Subject: 2026/90255 at location Wye, Wheelwright Drive, Dewsbury, WF13 4JB

Please see ecological commentary below:

Project Title
proposed site

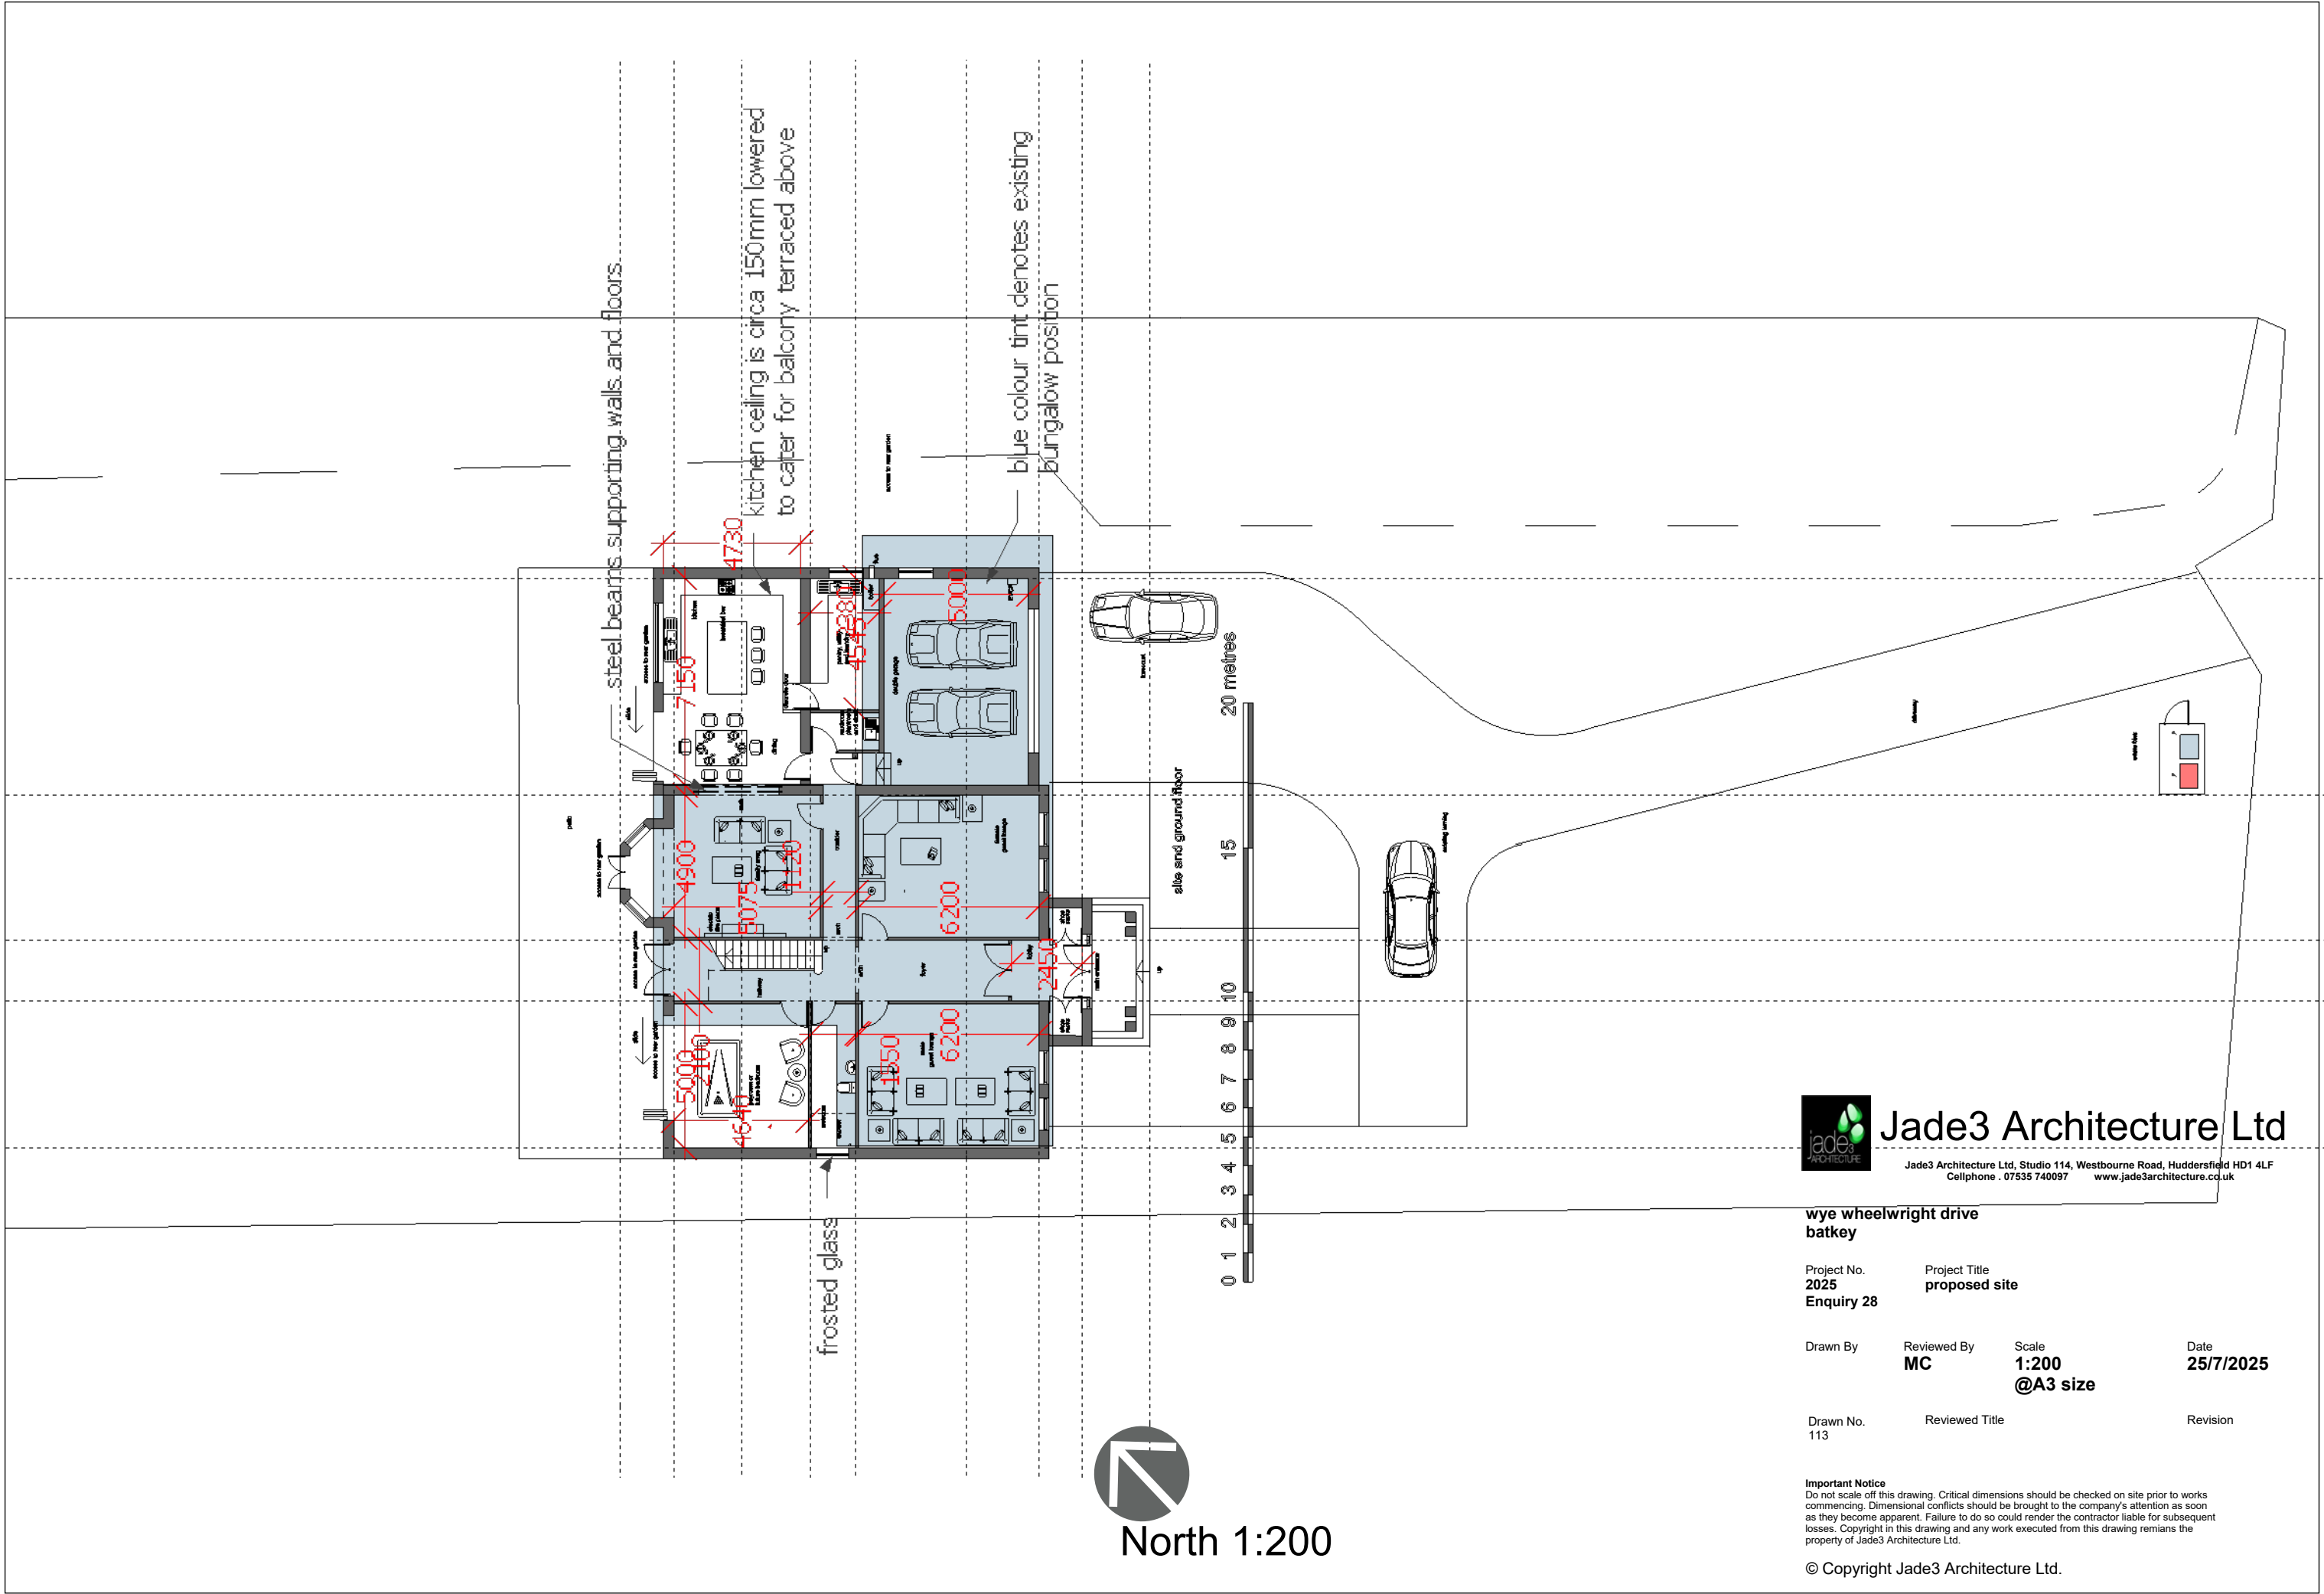
The site consists of 1 no building, hardstanding, vegetated garden, and 7no scattered trees, and an ornamental hedge.

All trees are to be retained onsite. The building is to be demolished. The site would offer opportunities for bats and birds. Tree protection measures and lighting strategy would need to be conditioned.

No photos of the building onsite, due to the fact it is to be demolished a Preliminary Bat Roost Assessment will need to be conducted prior to determination under Case Law (CO/2820/2008 / 2009 EWHC 1227(Admin)).

PBRA to be conducted and report provided prior to determination.

A Hedgerow and Tree Protection Plan detailing measures for the protection of trees and hedgerows during the works will be submitted to and approved by the LPA prior to the commencement of works on site, including site clearance and delivery of materials.
